Application Reference: Y/9/25/DOC	Initial Issue Date: 21/02/2025
Site Name: Fleurie Nursery Lake Lane Barnham PO22 0AL	Issue Date:
	Reviewer Reference: ADC/SB

Application Reference:	Y/9/25/DOC	Reviewer Reference:	ADC/SB
Planning Officer:	Amber Willard	Date of Review:	21/02/2025
Site Name:	Fleurie Nursery Lake Lane Barnham PO22 0AL		
Application Description:	Approval of details reserved by condition imposed under reference Y/26/24/PL relating to condition number 4 - surface water drainage scheme, condition number 5 - discharge flows to watercourses, condition number 6 - maintenance and management of the surface water drainage system and condition number 10 - Biodiversity Enhancement Layout.		
Assessment Number:	1 of 2

- Cover Letter Ref C2904 dated 17 December 2024
- C2904-P-201 Rev P1 – Proposed Contributing Area
- C2904-P-101 Rev P3 – Proposed Drainage Strategy
- C2904-P-501 Rev P1 – Proposed Typical Construction Details
- C2904-P-601 Rev P1 – OWC Application Sheet 1
- C2904-P-602 Rev P1 – OWC Application Sheet 2
- Storm Network KCK Attenuation_11.pfd [Fleurie, Lake Lane] dated 12.12.2024

PROPOSED BAGWORK HEADWALL FOR SW DRAINAGE  
(scale 1:20)

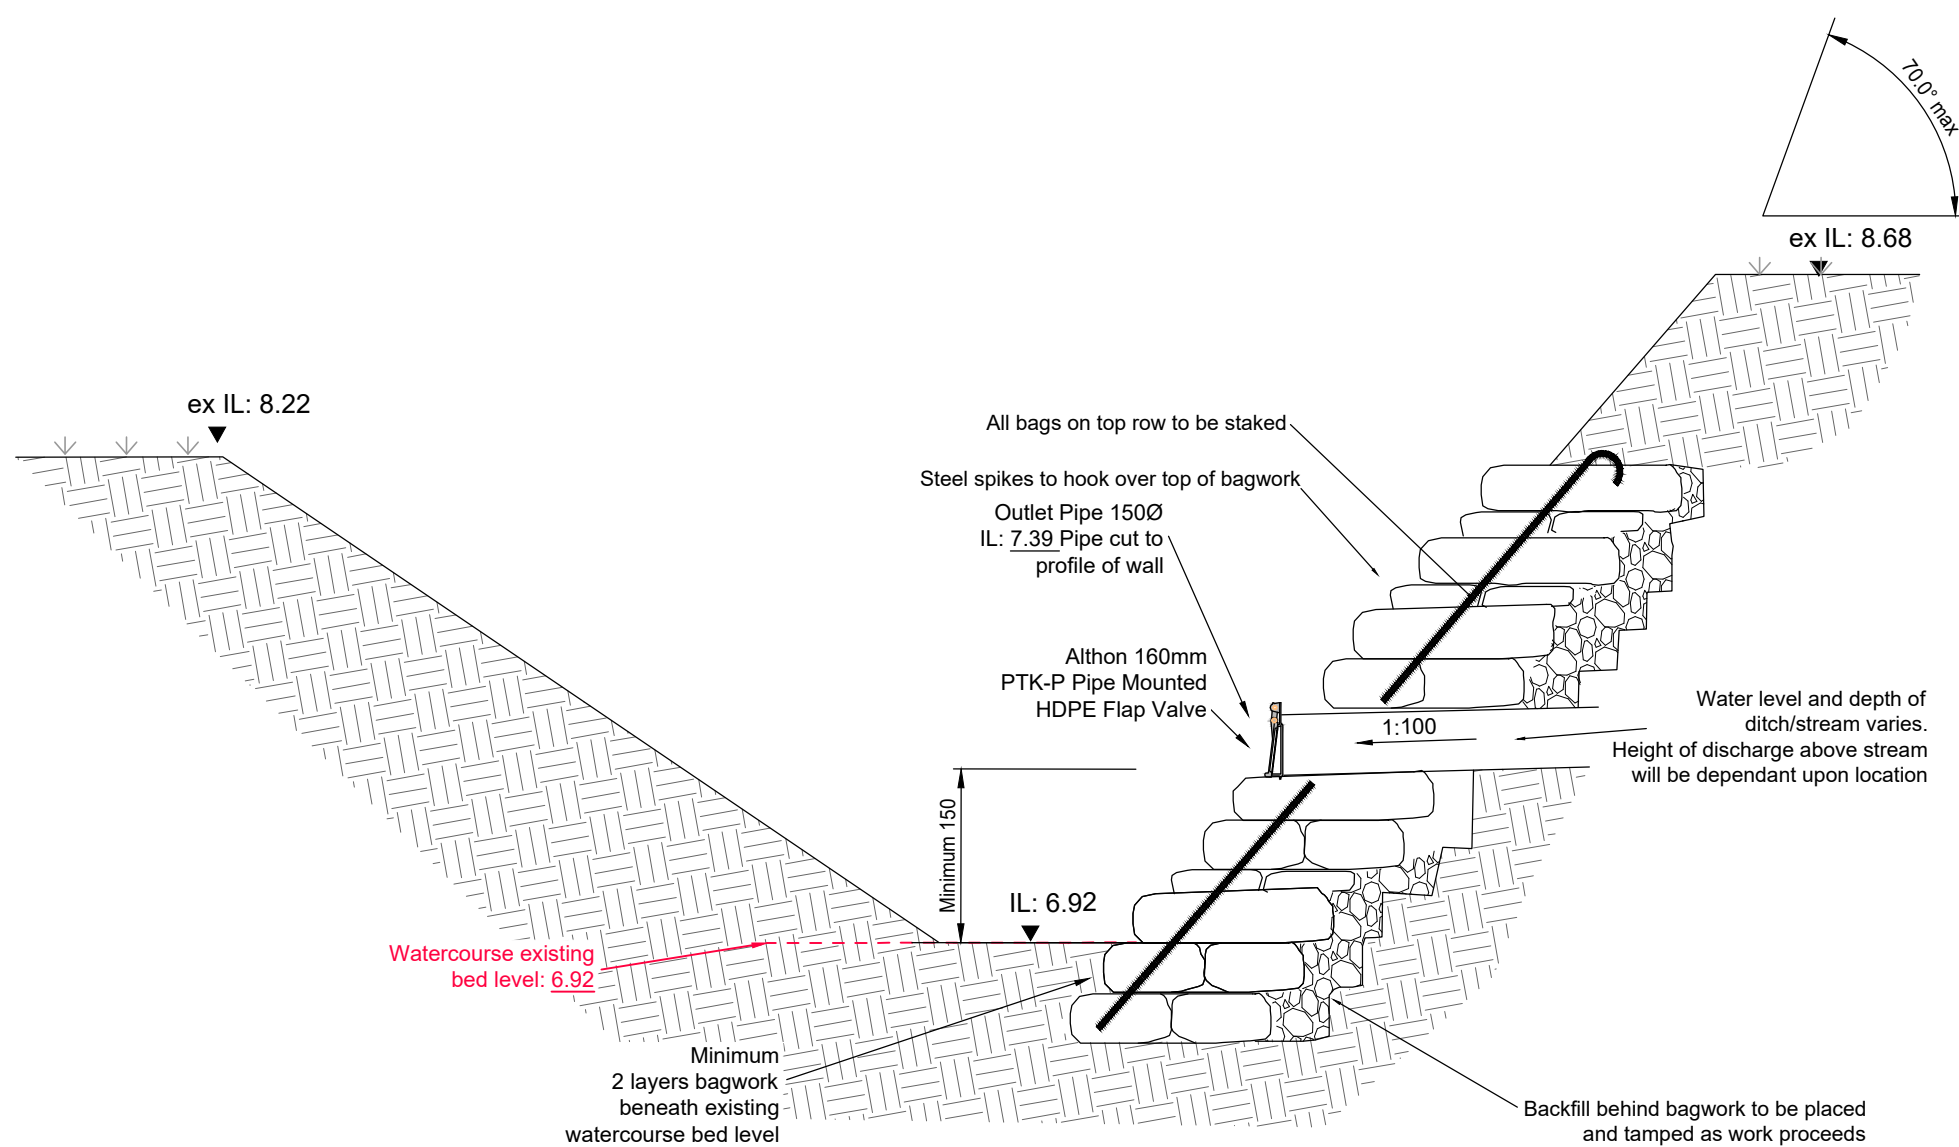
12.	The modelling does not include the flap valve.				
13.	Please remove the standard (non-site specific) headwall details from C2904-P-501. These contradict the OWC drawings which are more detailed and site specific.

DRAWN	KCK	ENGINEER	TZ	CHECKED	CS	APPROVED	CS
DATE	DECEMBER 2023	SCALE @ A1	1:200				
JOB No.	C2904	STATUS	P	DRAWING No.	101	REV.	P4

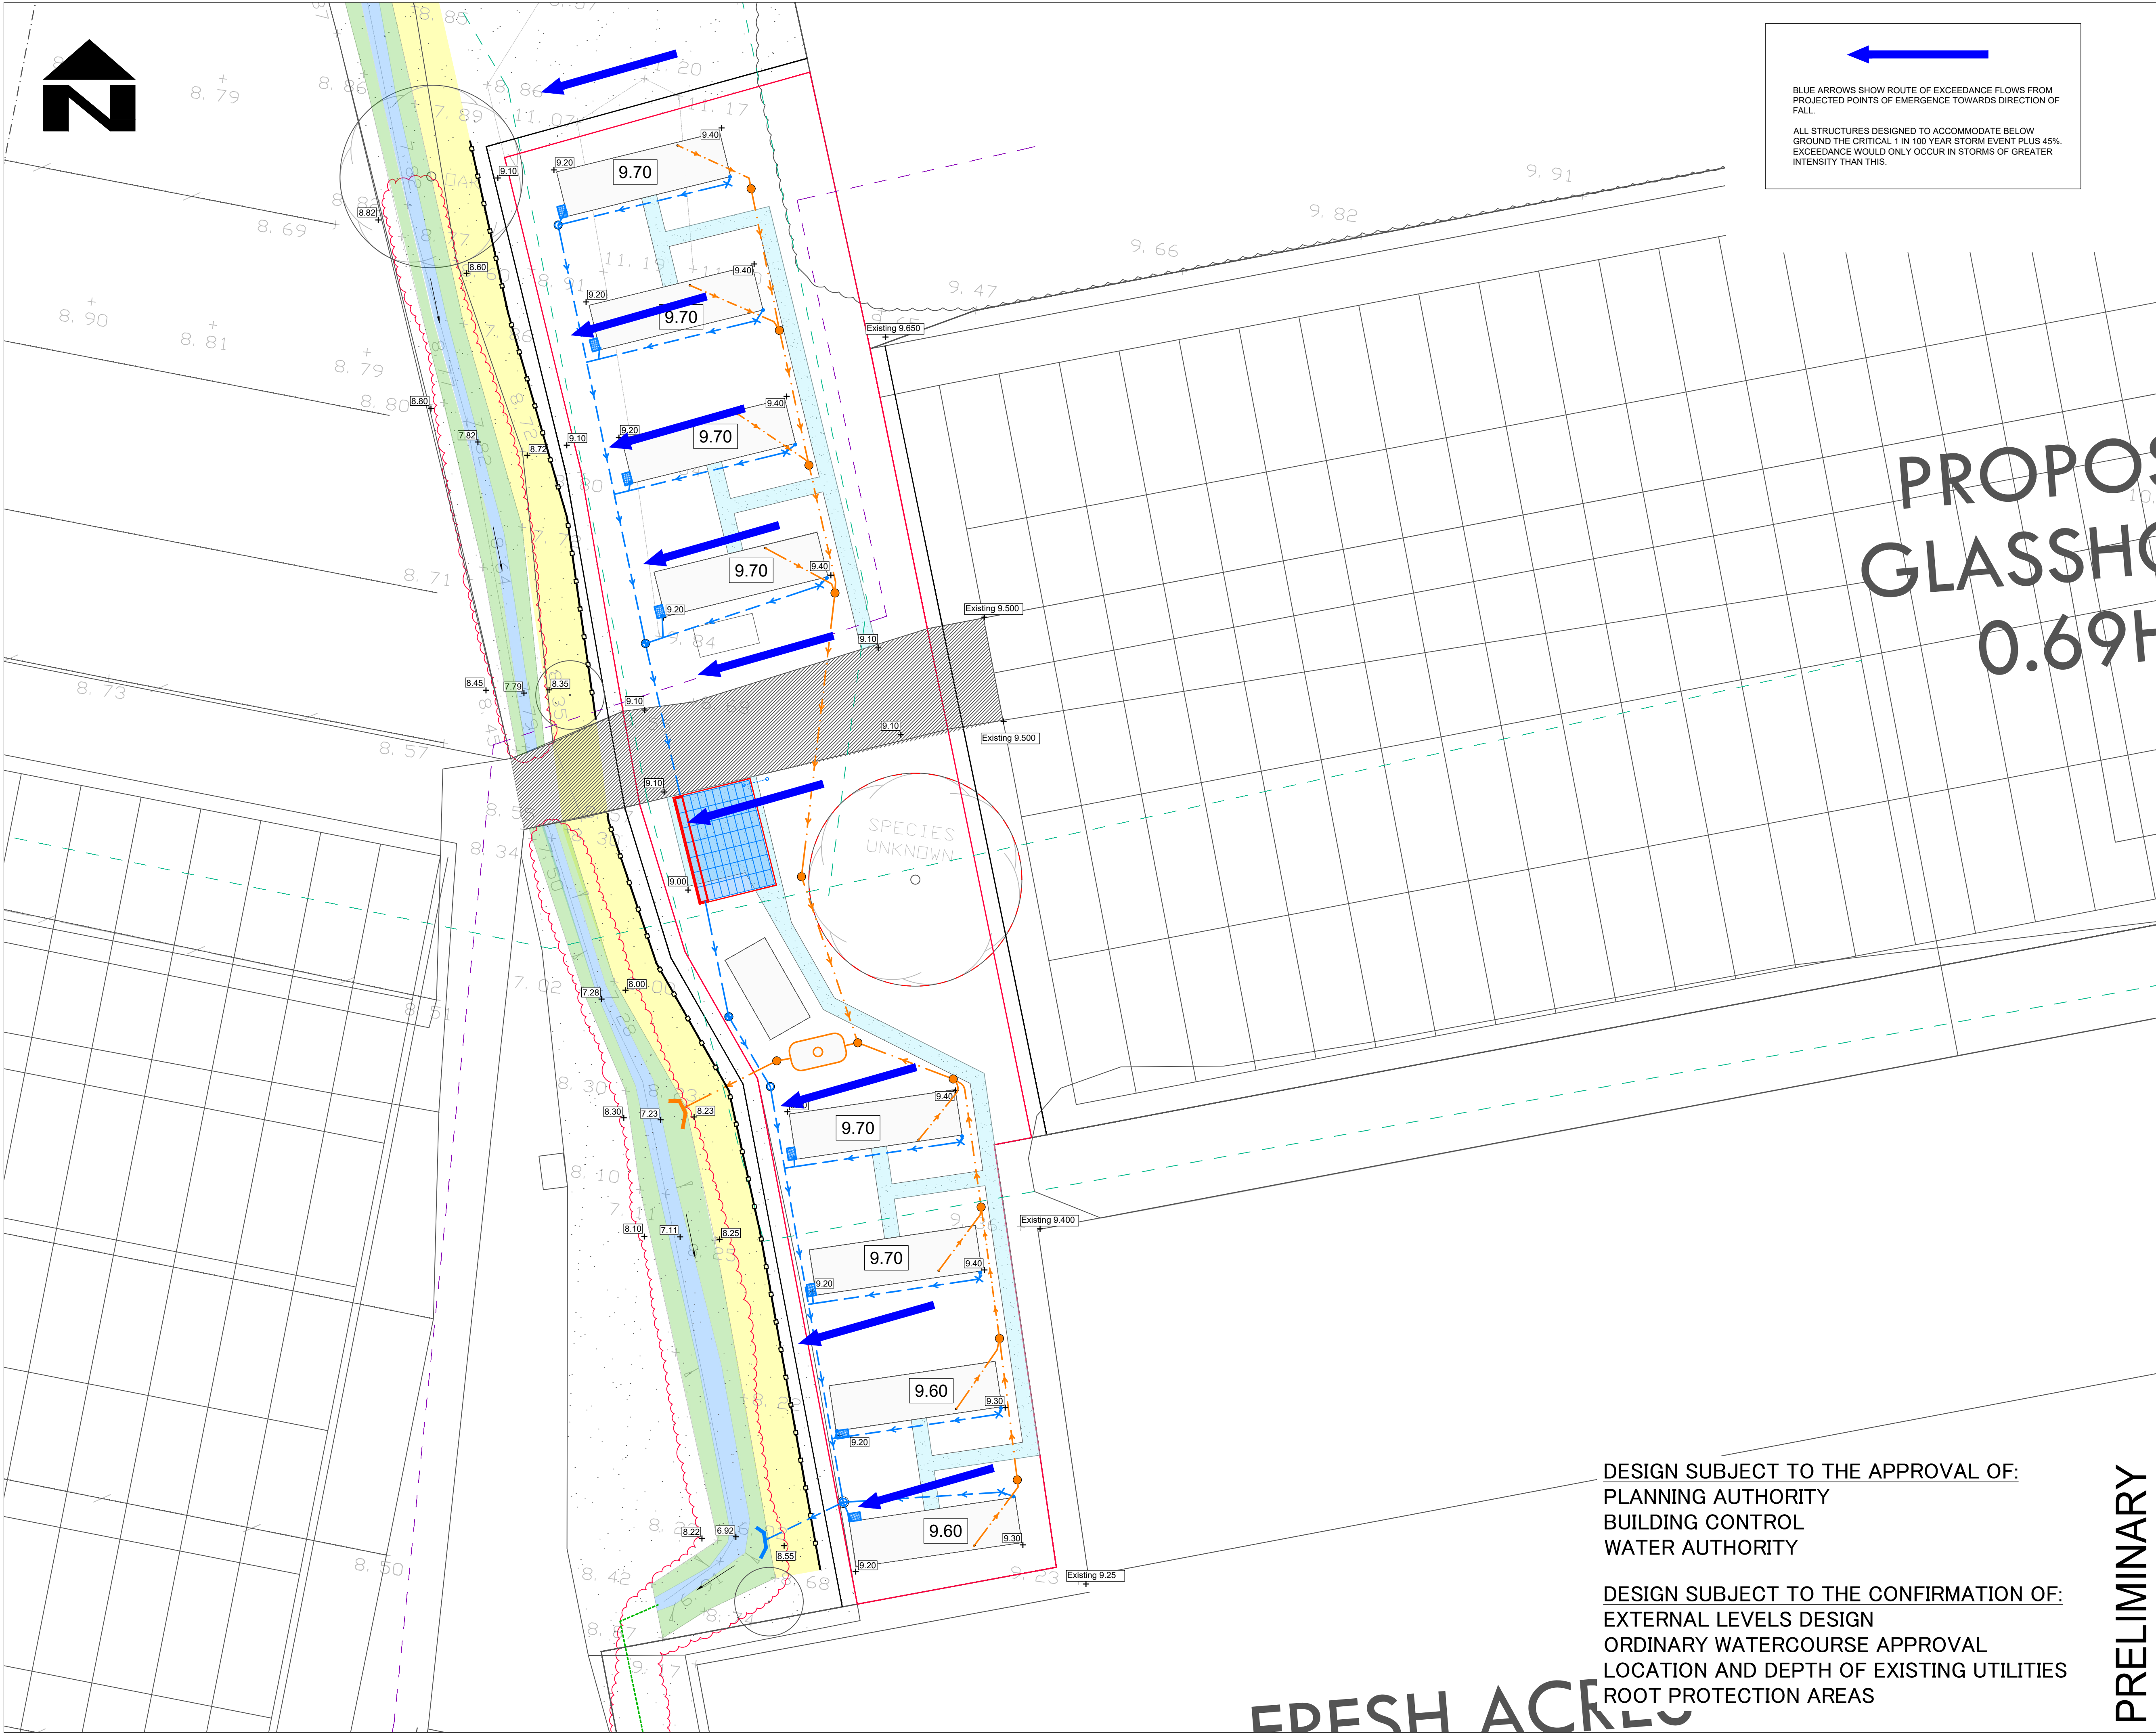
4.	Please correct discrepancies between cover and invert levels on the plans and the calculations. [It is acknowledged that this is unlikely to affect the design.]

6.	Please show any relevant easements on the plans.				
7.	Please demonstrate how any areas of surface water flood risk are accounted for within the design.

9.	The landscape and ecology management plan refers to a post and rail fence installed post-development to protect the rife. Please clearly demark this fence on the plans and ensure that is not within the easement for the watercourse.

10.	The existing access appears to be artificially raised (previous level 8.55, proposed level 9.10). This is also an area of surface water flood risk – see comment 7 – please justify the change in level and demonstrate any impact on flood risk.

11.	The orifice for S5 is described on the layout as being 500mm diameter. This is assumed to be a typo (confused with the chamber diameter), please correct.

16.	There is a risk of a clash between the surface water and foul drainage north of S4 and west of F6. Please adjust the design, if possible, to minimise this risk.
